**SSD-10468 EIS EXHIBITION
WAREHOUSE AND CUSTOMER FULFILMENT CENTRE
74 EDINBURGH ROAD, MARRICKVILLE**

TfNSW has reviewed the EIS and provides the following advisory comments for the Department's consideration in **TAB A**.

**Brendan Pegg
Senior Land Use Planner
Planning and Programs, Greater Sydney Division**

**20.0m ARTICULATED
 VEHICLE SWEEP PATHS**

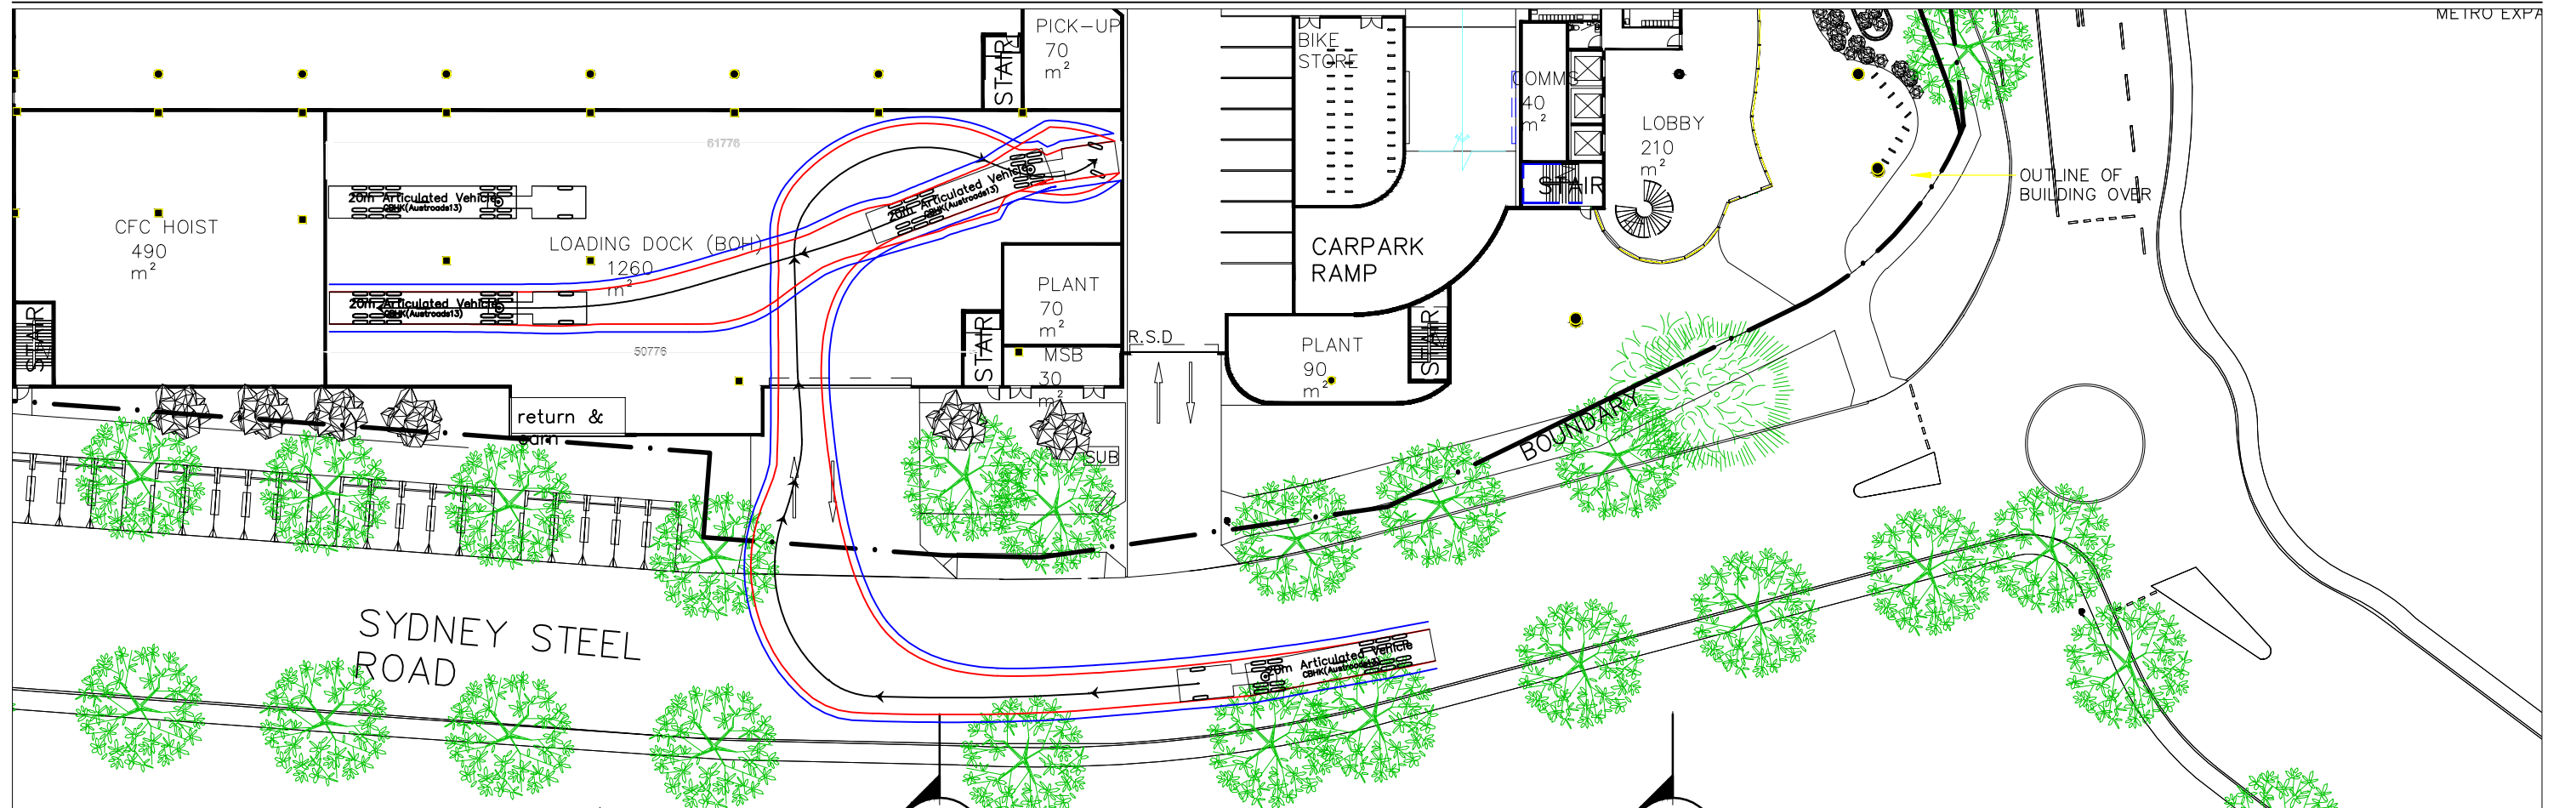
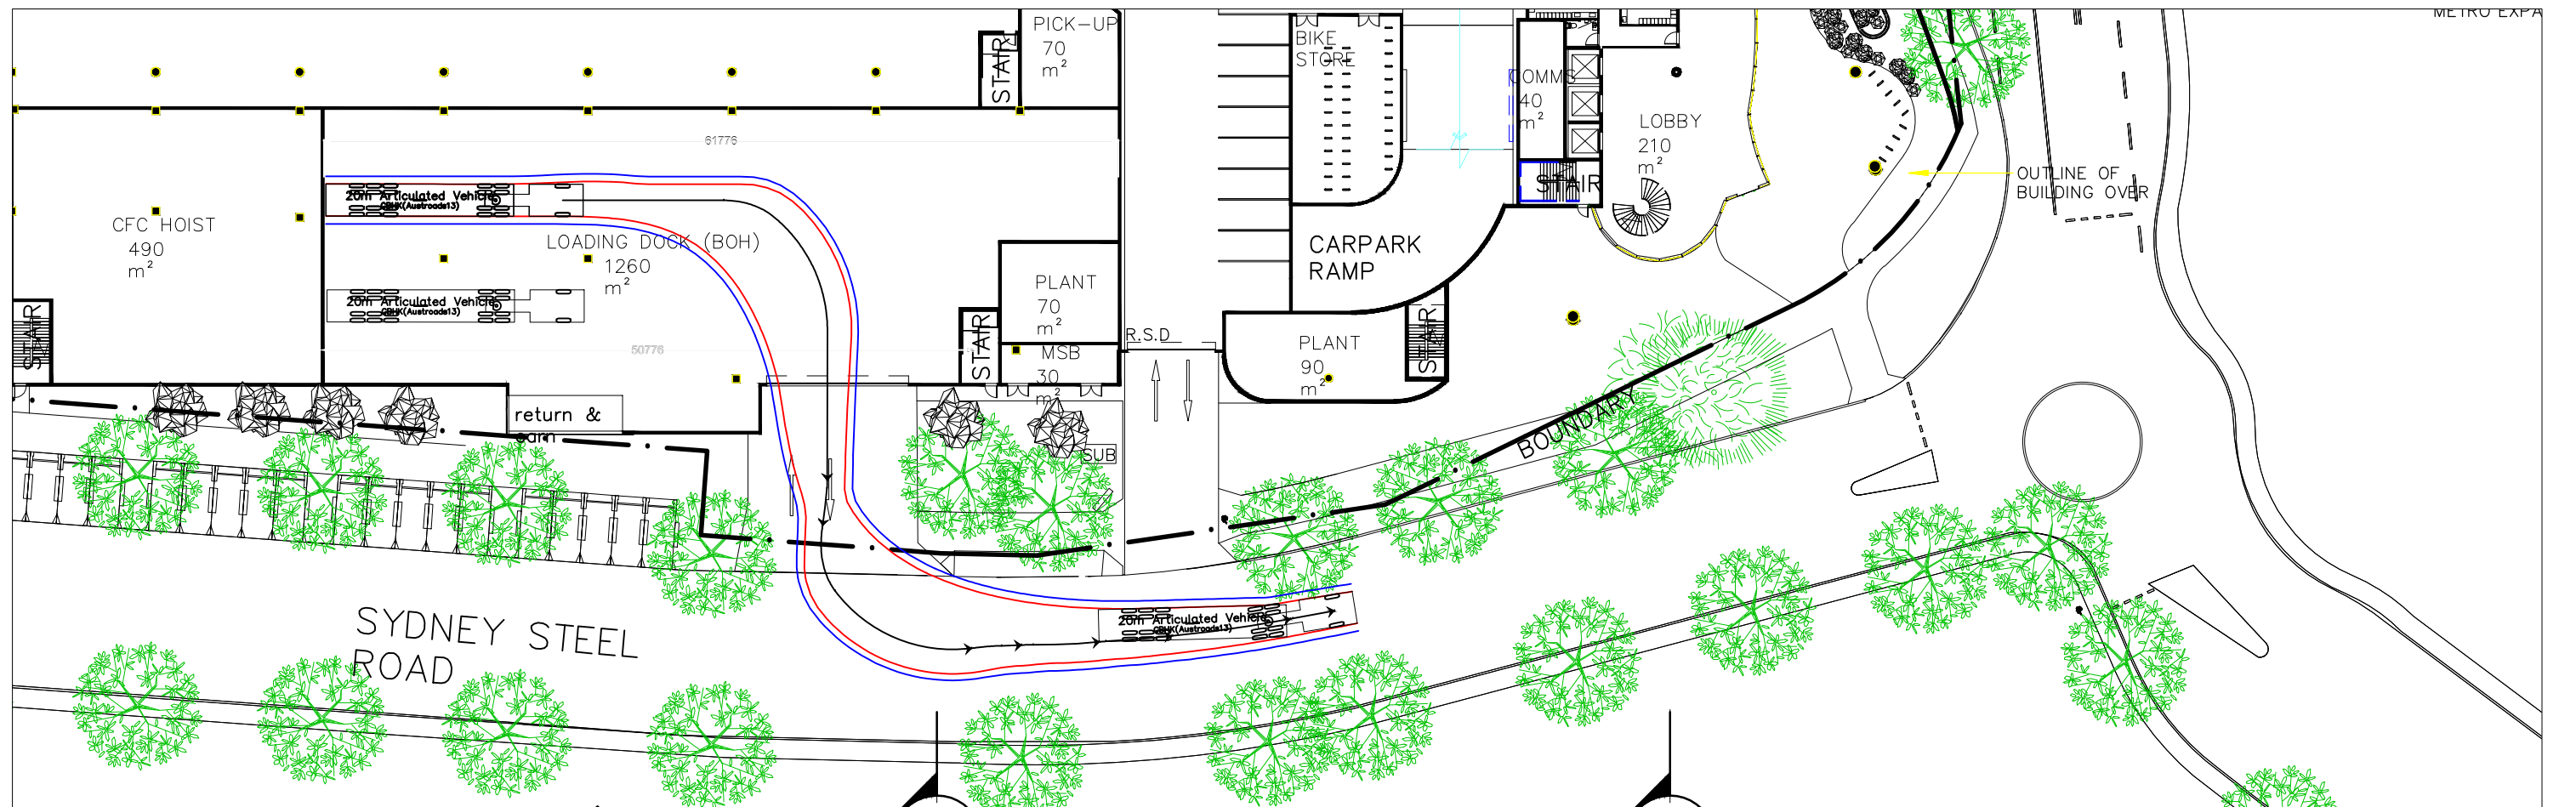
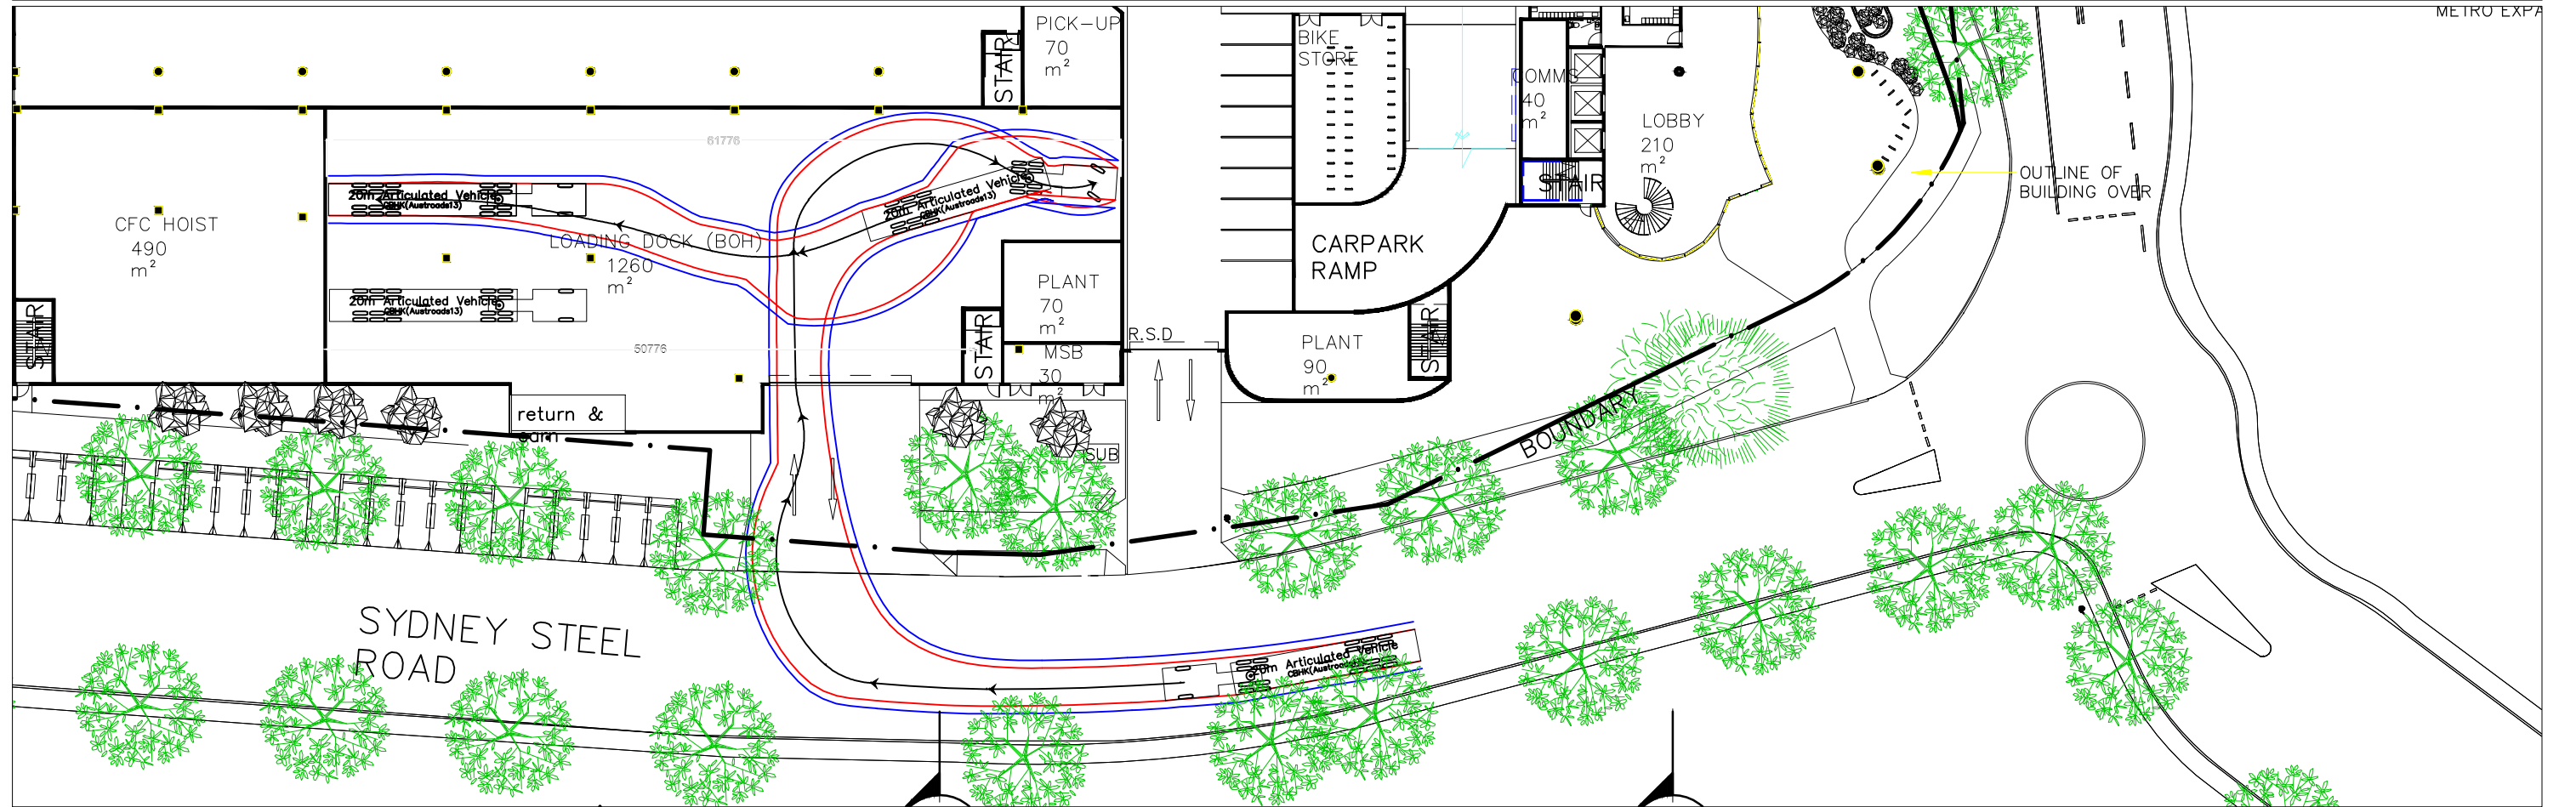
Section 3.20 states that "*Deliveries to the customer fulfilment centre will be made by semi-trailers up to 20 metres long*". TfNSW questions the suitability of the local road network to accommodate for such vehicles.

TfNSW has reviewed the internal swept paths for the site and notes that the semi-trailer movement (Sheet 9 in the TIA) is only illustrating the end docking space being utilised. For the other seven loading dock spaces to be utilised, TfNSW believes that the movements may encroach on the car parking spaces.

The proponent is to review the swept path of all semi-trailer movements to ensure that the vehicles can operate without impacting the proposed car parking areas.

PRELIMINARY PLAN

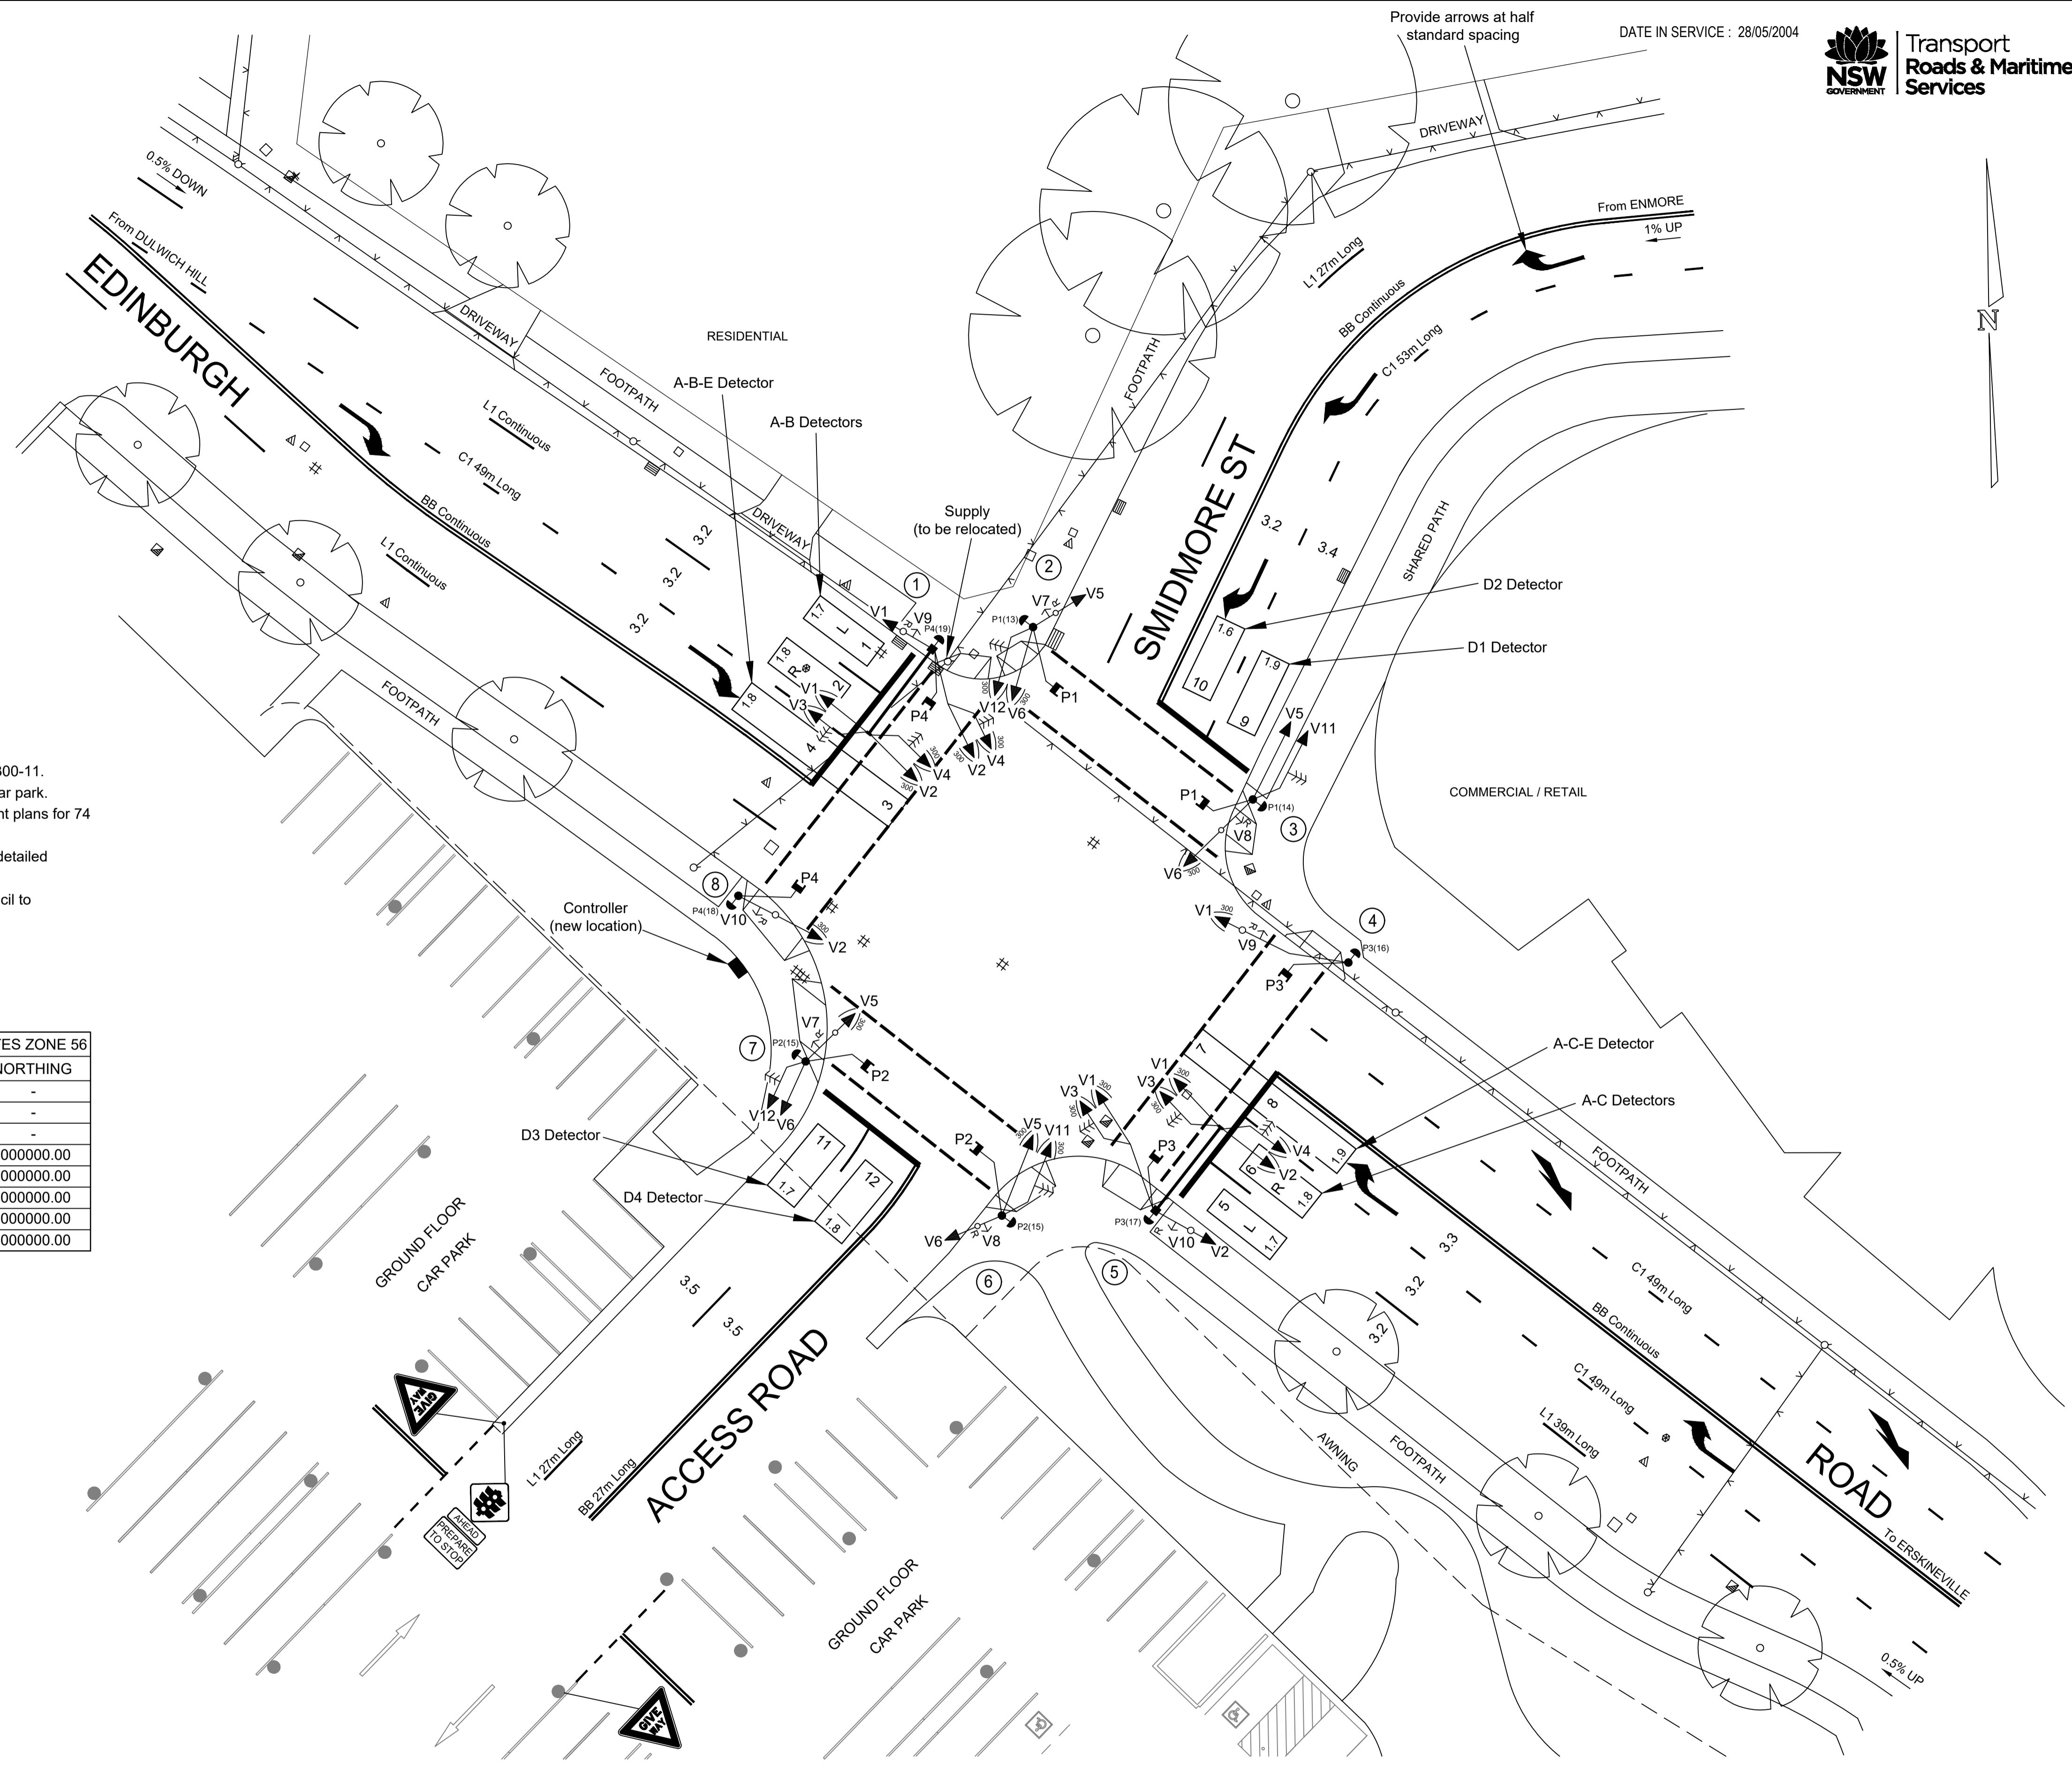
This arrangement involves the modification of an existing Traffic Control Site (TCS) at Edinburgh Road / Smidmore Street, which requires TfNSW to provide approval under Section 87 of the *Roads Act 1993*. Whilst this was done previously under DA 2015/00168, as the conditions of the network have changed (including recent redevelopments such as Marrickville Metro Shopping Centre), TfNSW requires:

- Electronic copy of the SIDRA modelling data, which includes current and future use of the intersection layout; and
- Swept path analysis for the turning movements proposed with the largest size vehicle with all movements at the proposed additional leg of the intersection.

Limited details regarding changes to TCS phasing at the intersection of Smidmore Street / Edinburgh Road have been provided.

TfNSW advises that 'in-principle' support is given to the right hand movement and creation of diamond phase is supported, subject to being supported by the modelling and capacity to be accommodated.
